CITY OF ALBUQUERQUE

February 12, 2016

Re: Taco Bell Renovations
4815 4th St NW
Request for 4-Day Temporary C.O. - Accepted
Engineer's Stamp dated: 8-17-15 (F14D071)
Certification dated: N/A

C-101

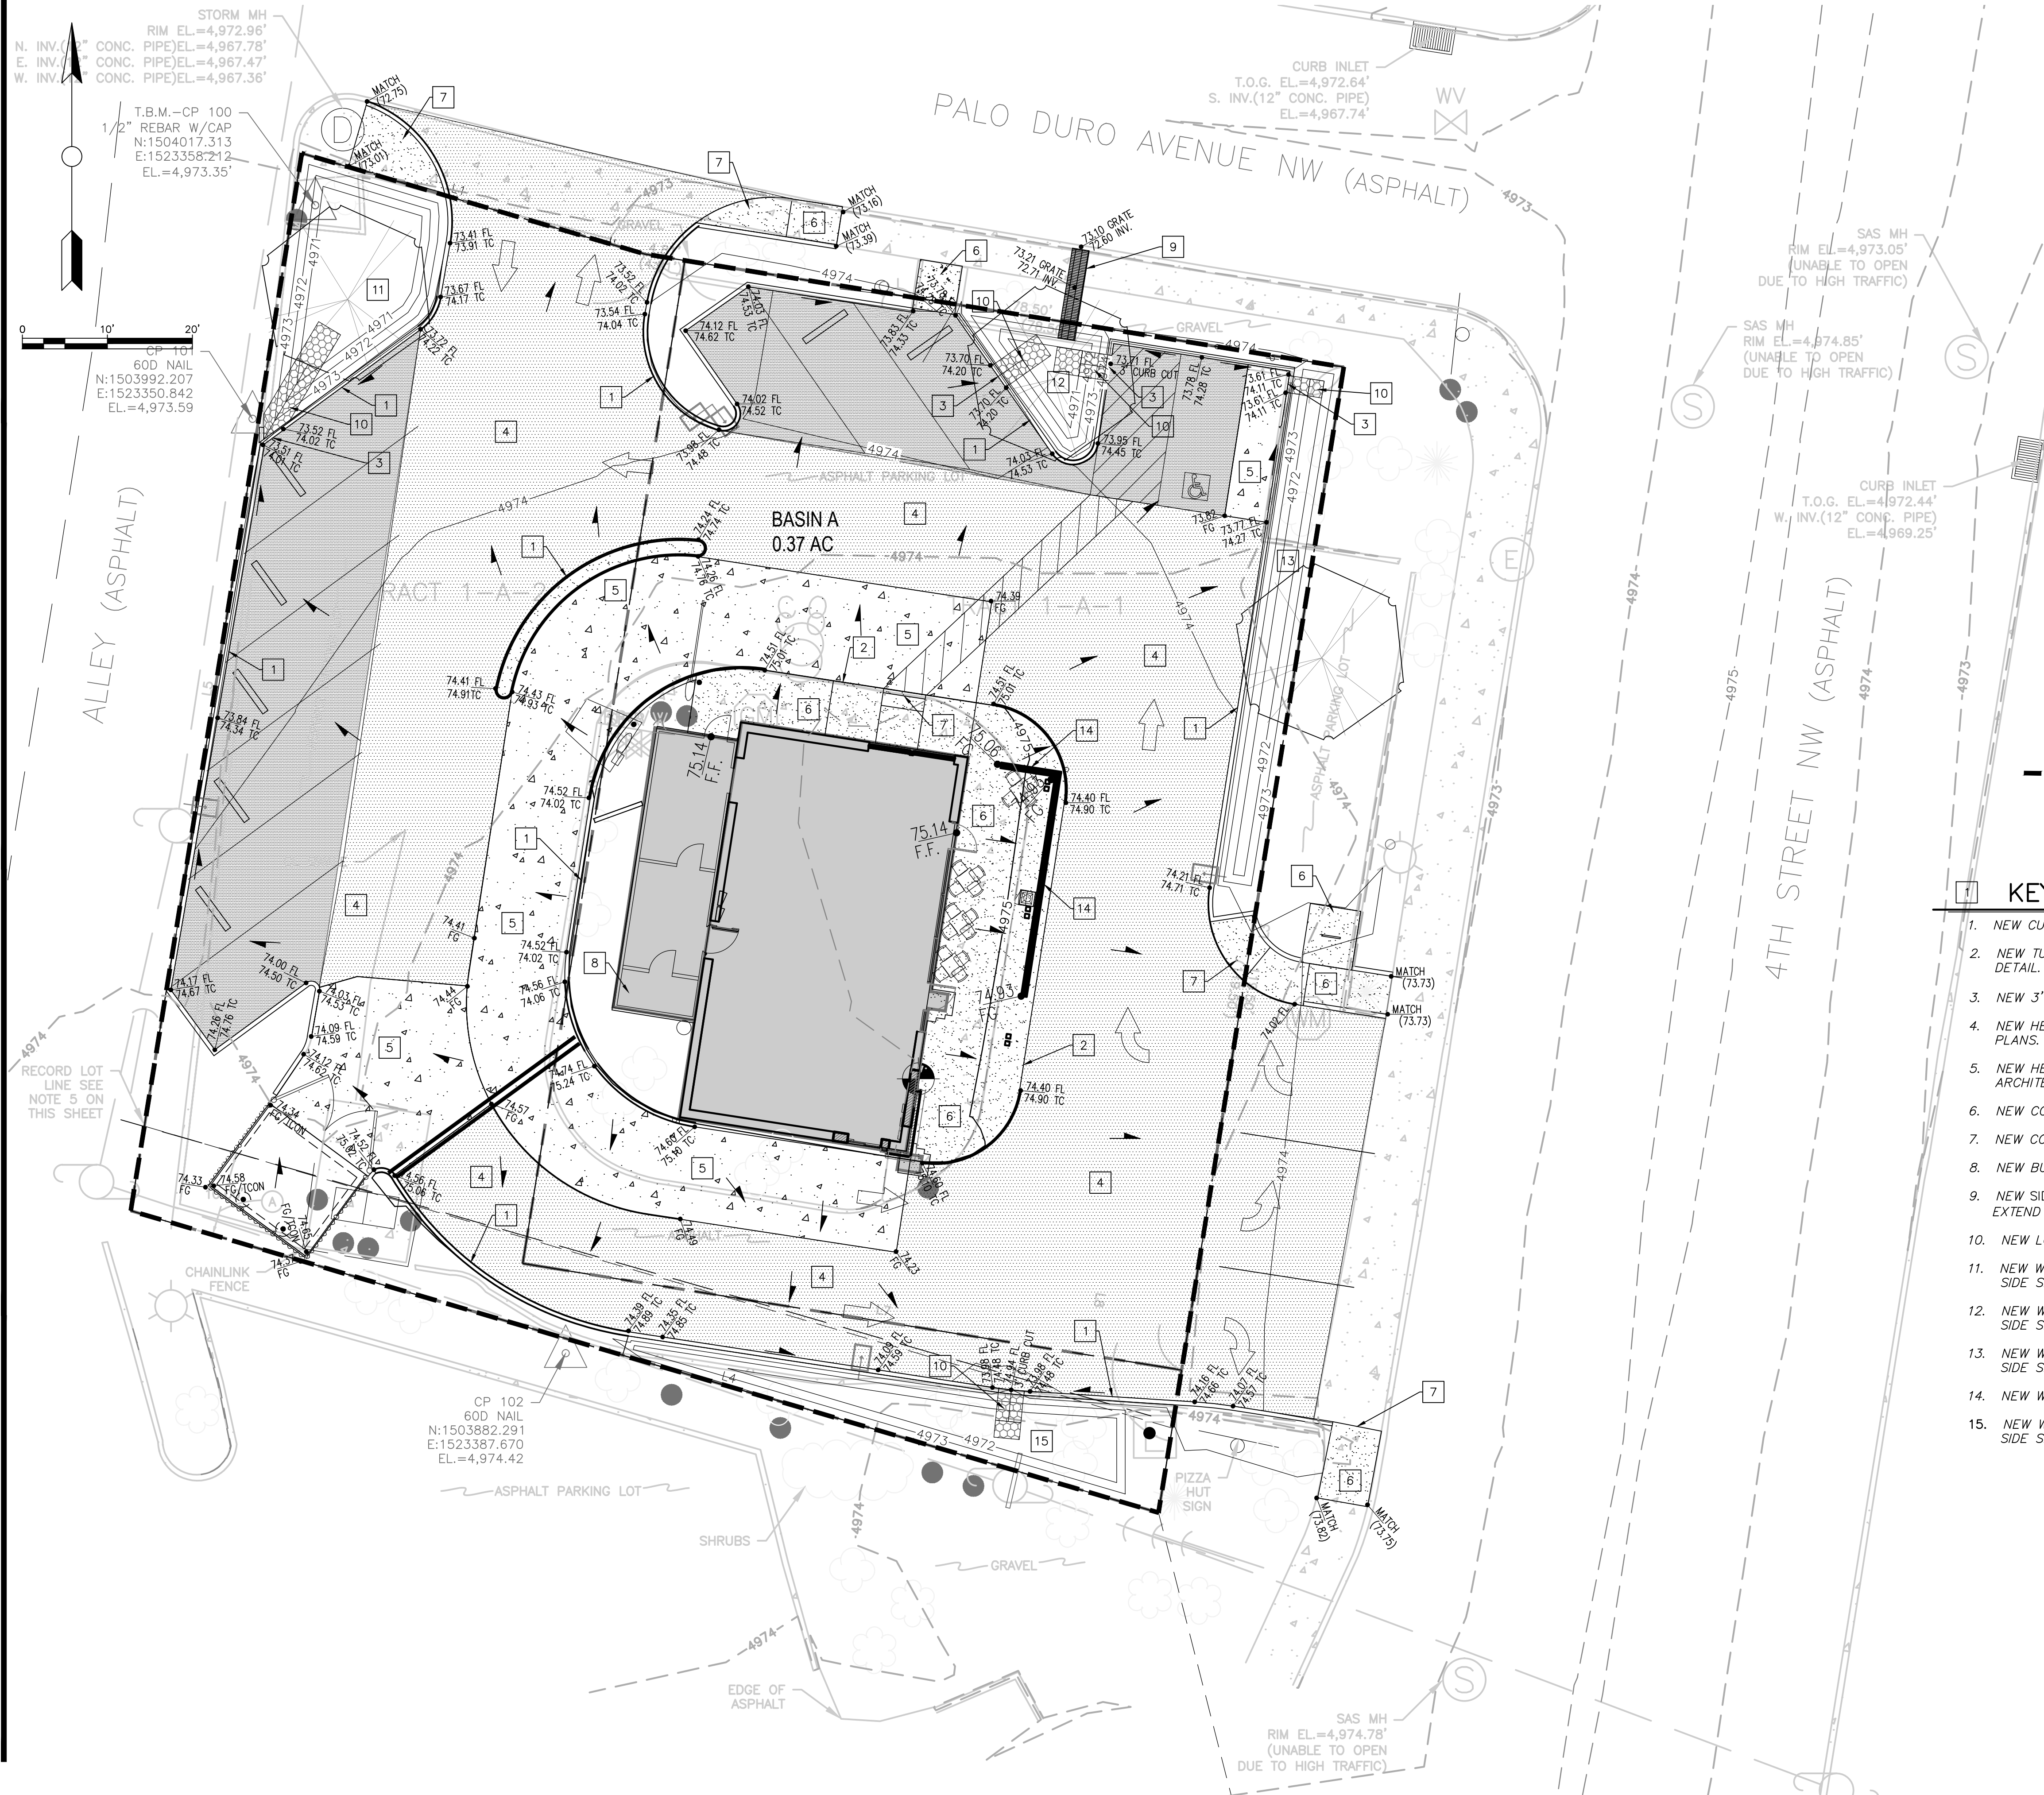
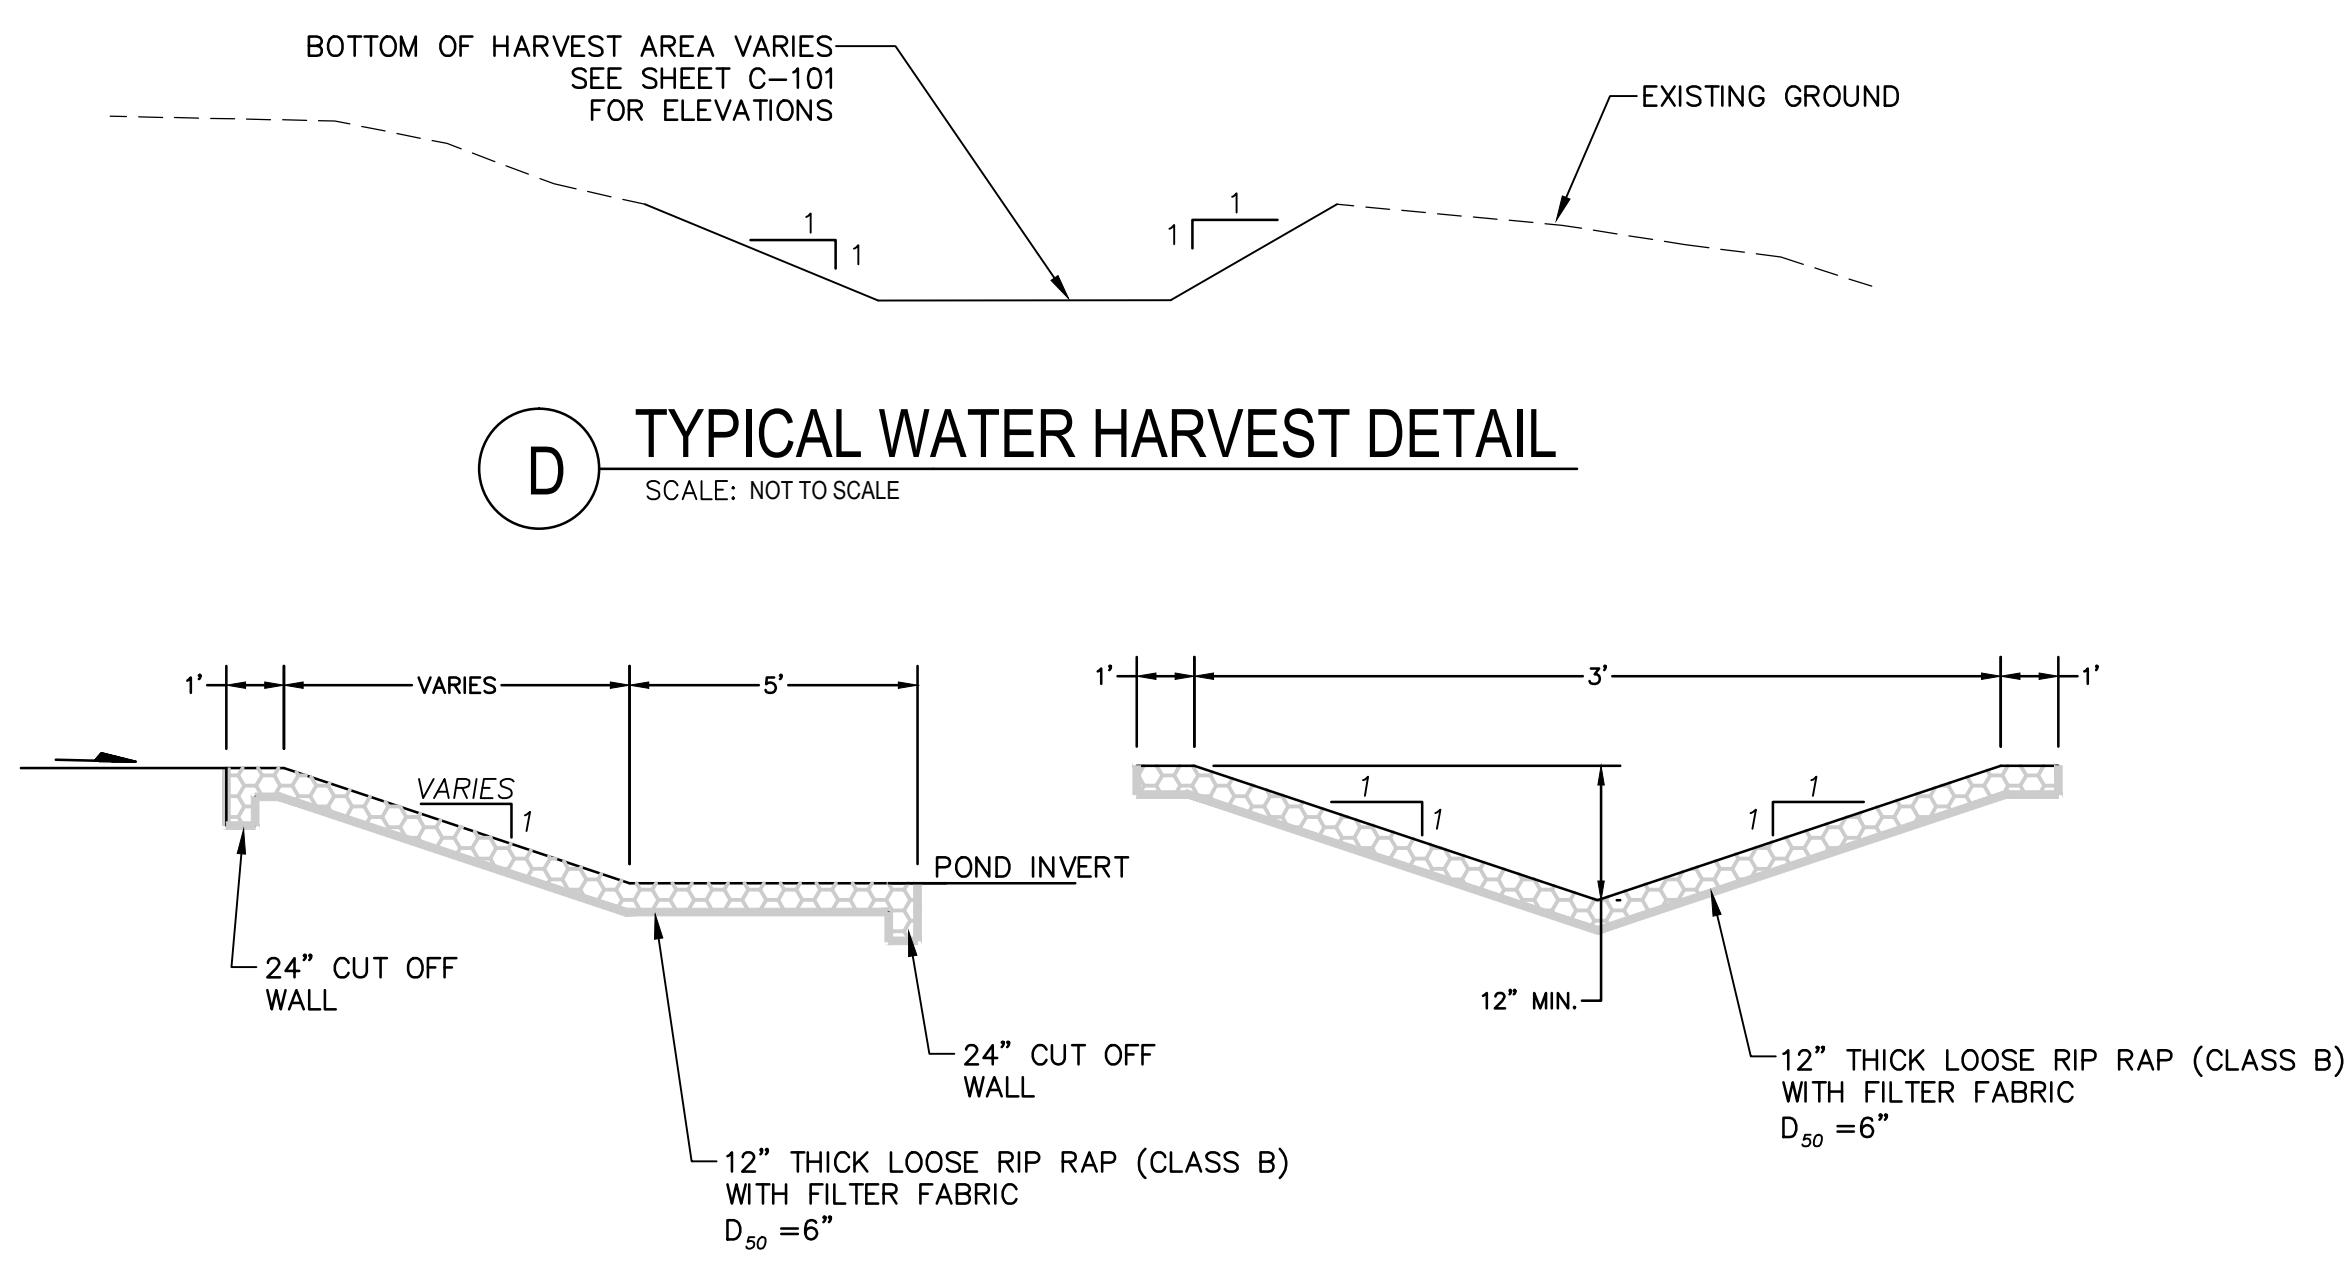
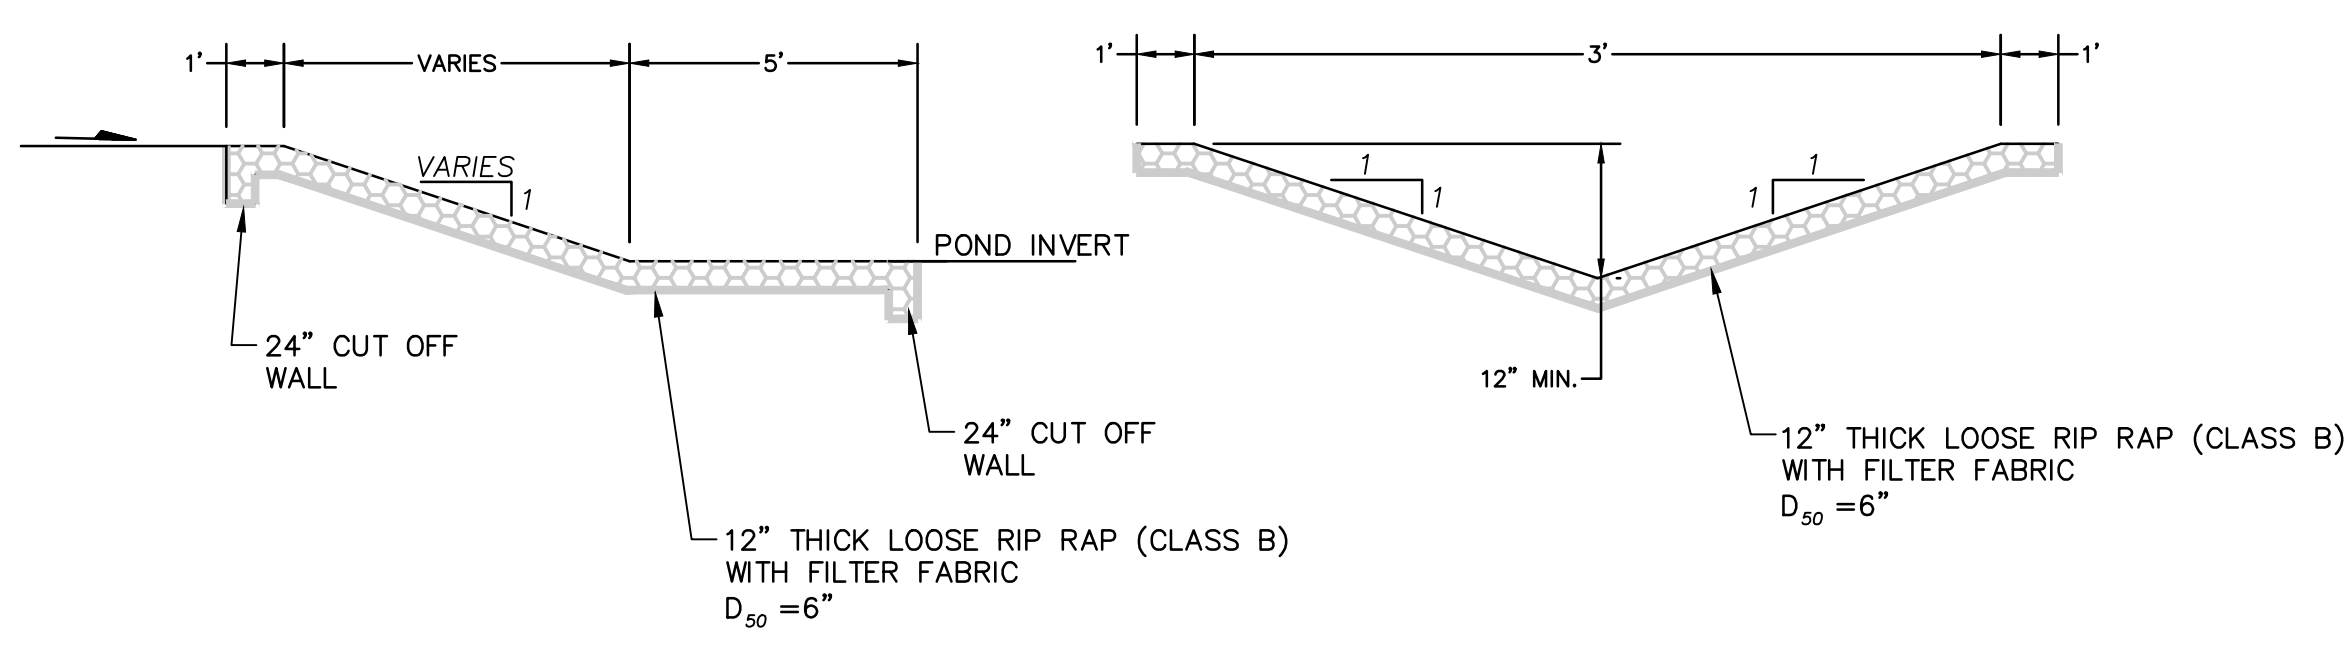
- Submit approved grading and drainage drawing with engineer stamp date of 8-26-15.
- The sidewalk culvert must be completed. Until it is complete it must remain barricaded with "Sidewalk Closed" signs on both sides starting at each entrance to the site. The bottom of water harvest on this pond needs to be approximately 3'-3" below TOC.
- The pond that diverts to the above mention culvert needs to be graded to flow into the culvert.
- The bottom of water harvest on the NW corner needs to be approximately 3'-3" below TOC.
- The 3' curb cut is missing from this water harvest area.
- The bottom of water harvest on the SE corner needs to be approximately 2'-3" below TOC.
- The bottom of water harvest on the east side needs to be approximately 2'3" below TOC.
